From: Planning JPA [REDACTED]
Sent: 02 December 2018 22:18
To: Simon Davis
Subject: RE: FP/171/18/PL - pre commencement conditions

Project	NEW DWELLINGS LAND OFF STANHORN GROVE FELPHAM BOGNOR REGIS				Drawing	LINCOLN - PLANS & ELEVATIONS - BRICK	
Client	WORTHING HOMES GROUP				Job-Dwg Number	17094-PL-3-10	
Status	PLANNING				Rev.		-
Scale	1:100	Sheet Size		A3			
Author	RR	Checked	JP	Date	19/04/18

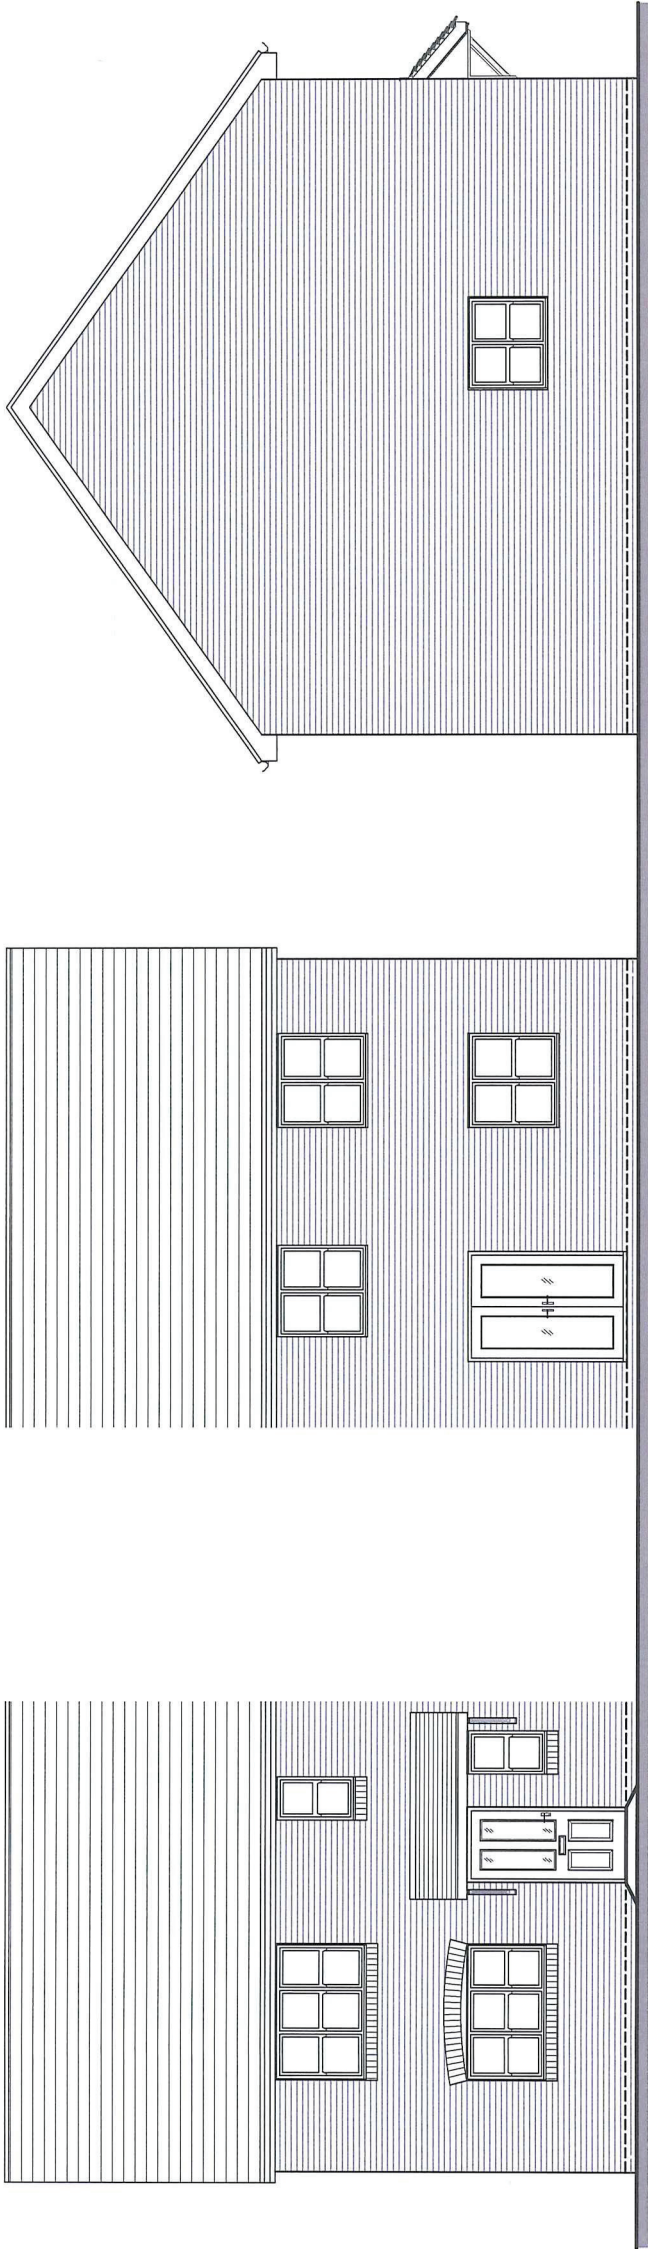
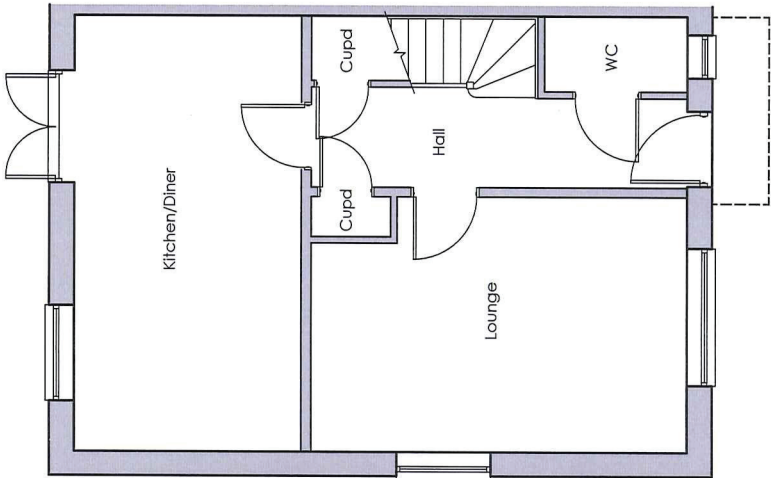
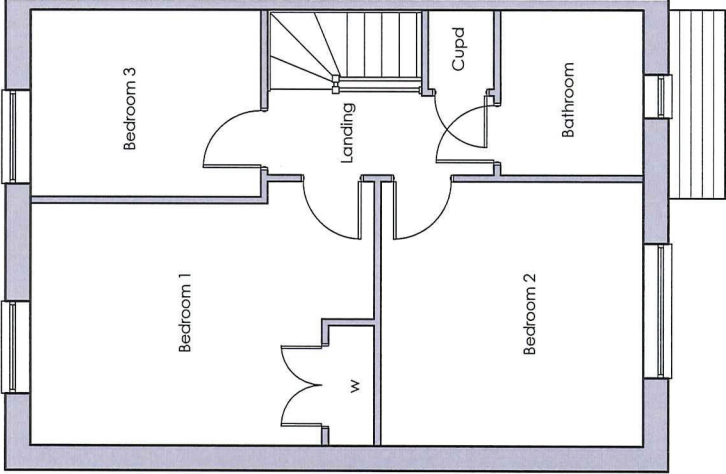
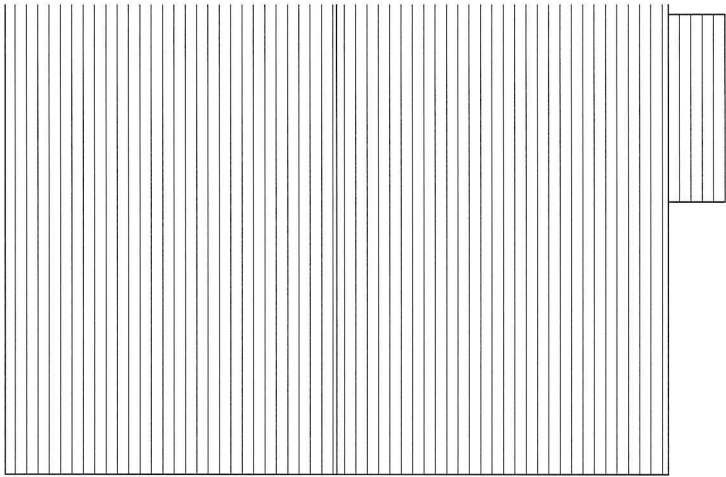
Typo on Lincoln plans and elevation - two plan 11's and should be plans 10 and 11.
